Online Comment

Application H01-0035-17
Location Land south of Moulton Chapel Road Cowbit Spalding PE12 6XA
Proposal Proposed residential development of up to 17 dwellings

Name Glen Chapman
Address Environmental Services

Date Submitted 20-01-17
For/Against Comments

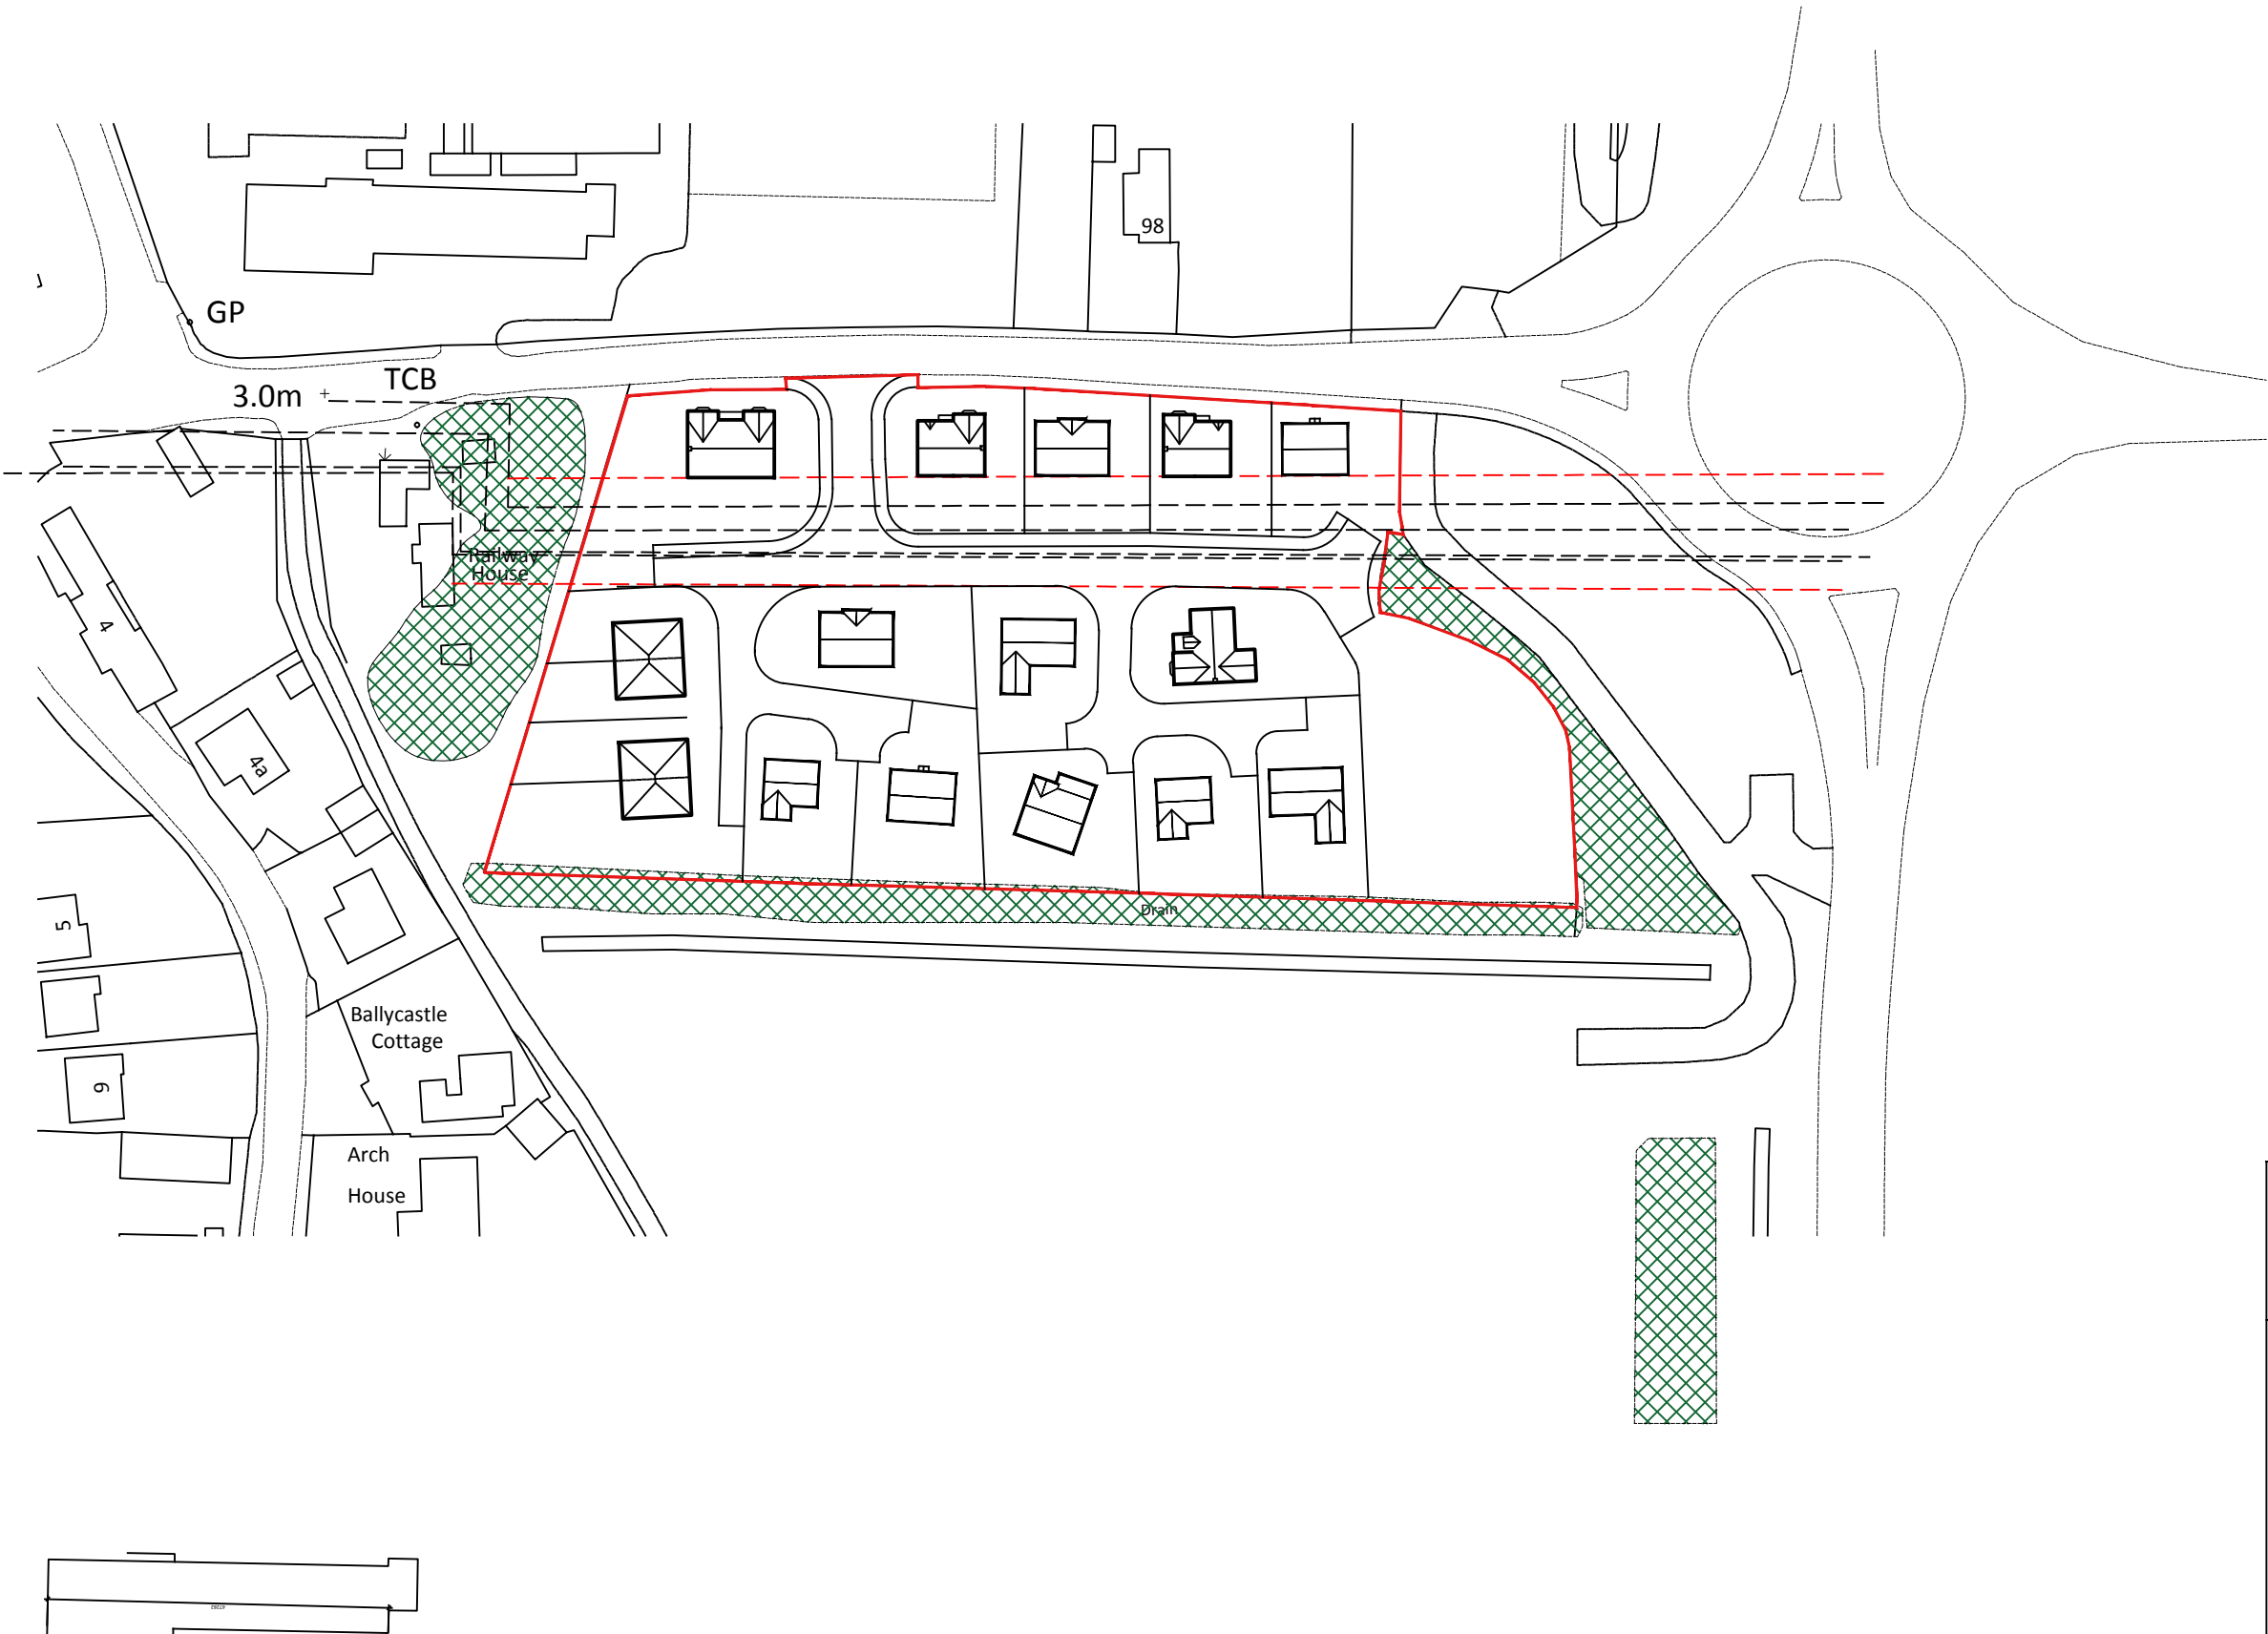
Access roadways to all residential properties should be constructed to an adoptable standard under an agreement with Lincolnshire County Council so that they will become public highways. This will enable refuse/recycling collections to be carried out from outside individual properties without the need for communal collection points at the point where private driveways adjoin public highways.

If not utilised correctly communal collection points become areas of dispute for residents of adjacent properties.

Should it be agreed that communal collection points will form part of this development the position of those collection points should be made clear to the potential occupiers of the properties nearby. This should not just be to the properties that will need to use the collection points but also the ones who will have them outside their properties.
